From: Simon Davis
Sent: 08 October 2021 15:03
To: alastair tindle [REDACTED]
Cc: Clarke, Adrian [REDACTED]; Shore, Emma
[REDACTED] Joanne Prichard [REDACTED]
[REDACTED] robin Henderson [REDACTED]
Subject: RE: Pagham, Construction and Environmental Management Plan

Secondly, I had proposed a condition to secure full details of the Tern Island before its implementation but Natural England are of the view that this has already been provided. We have the Location Plan Drawing G. the PHOC - Realignment Drawing A, the Managed Breach of Shingle Spit at Pagham Further Information and Marine Licence June 2021 & May 2016 documents and the Pagham Adaptive Management Report No. 1 (May 2021). I can't see such detail in these items. Please advise and if so, highlight where this info is.

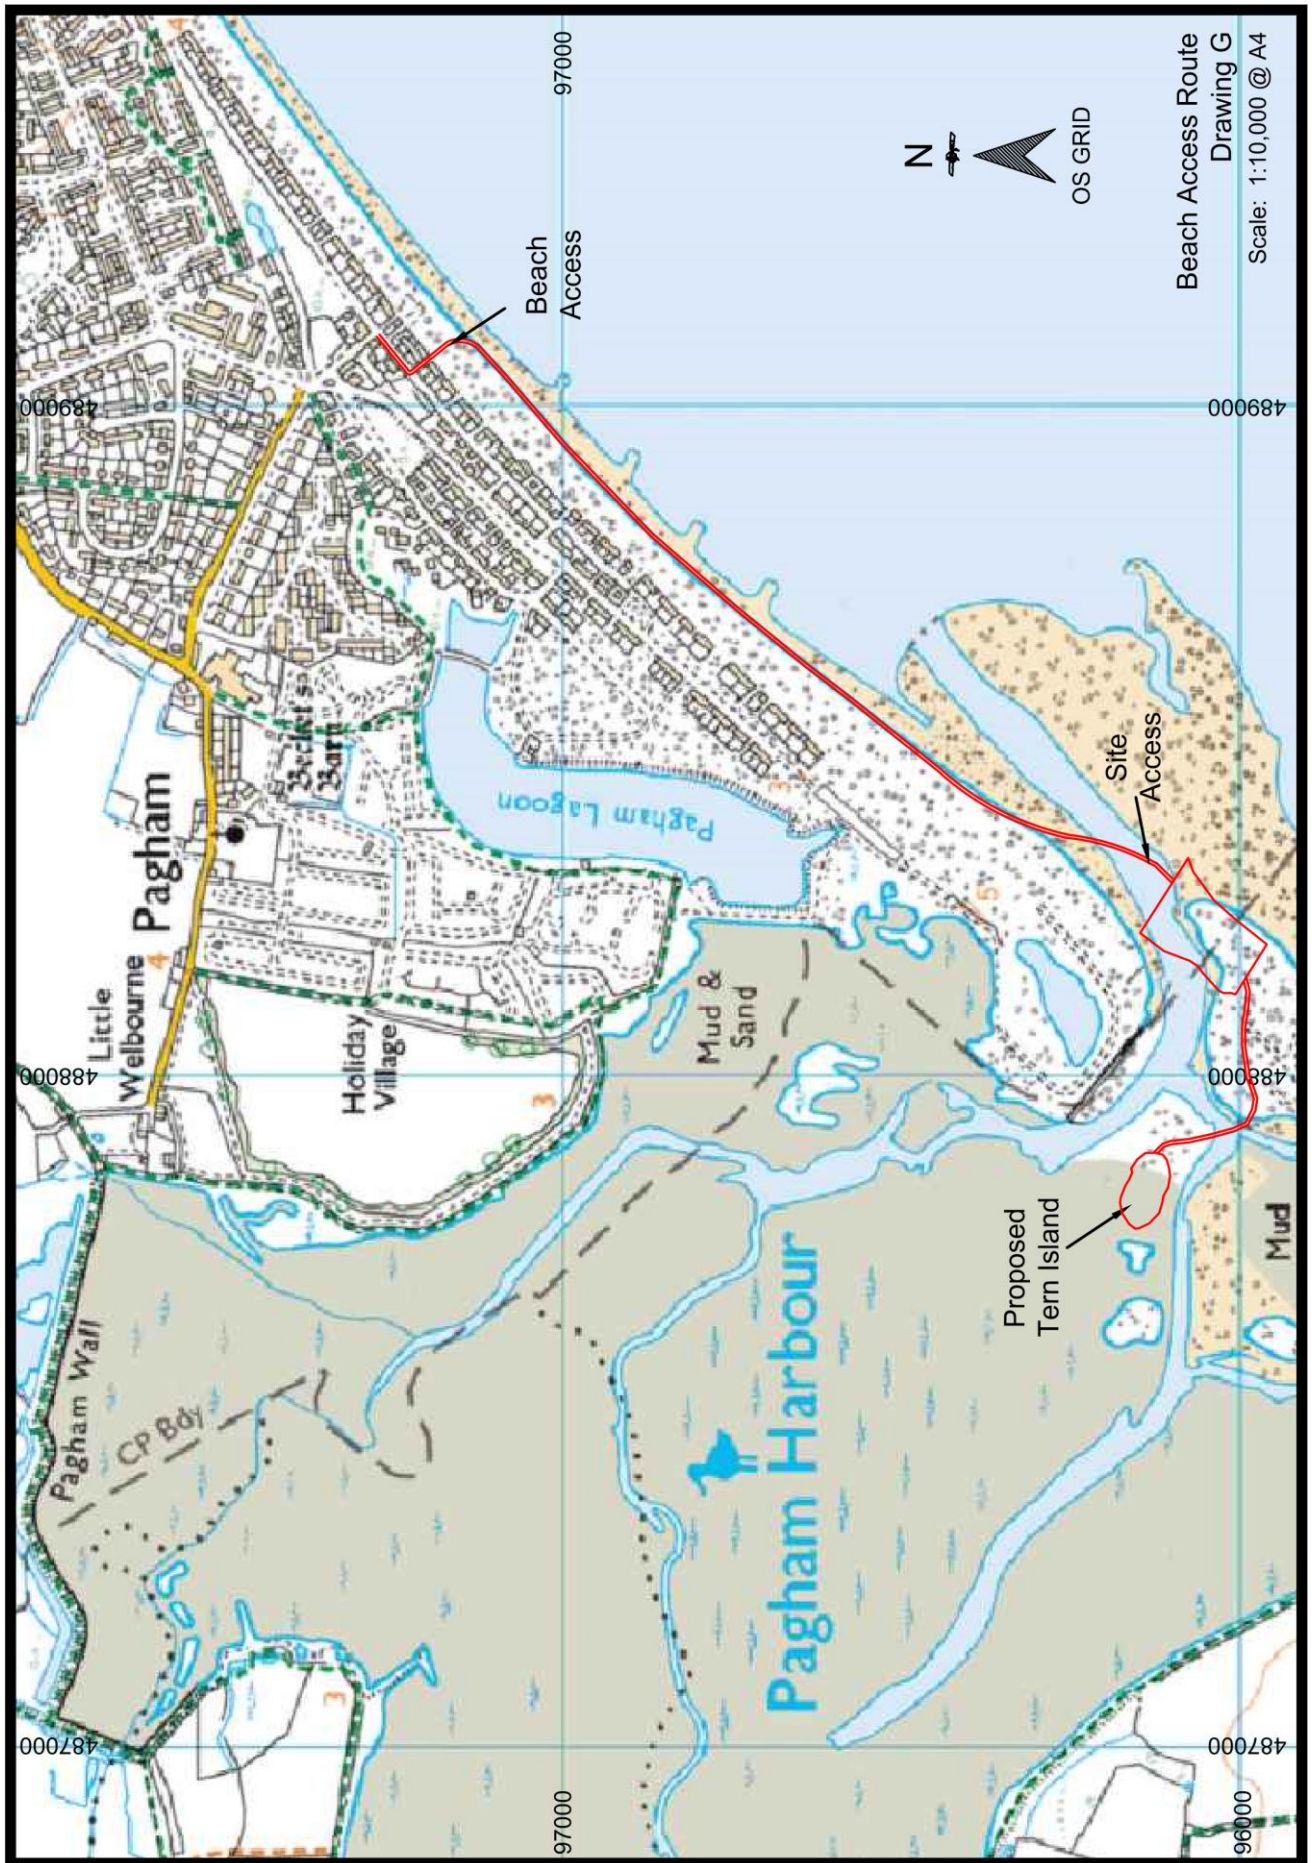
- timings of work to occur at low tide to reduce risk of sediment suspension.
- tern island shingle deposition to occur at low tide to minimise sedimentation.
- Temporary plant parking should avoid sensitive habitat features and should not be stored on the church Norton spit overnight (they haven't seen details of overnight parking, though assume it'll be in base compound area in car park)
- Cold works mitigation should be included in CEMP
- Details of briefing watches should be included in CEMP
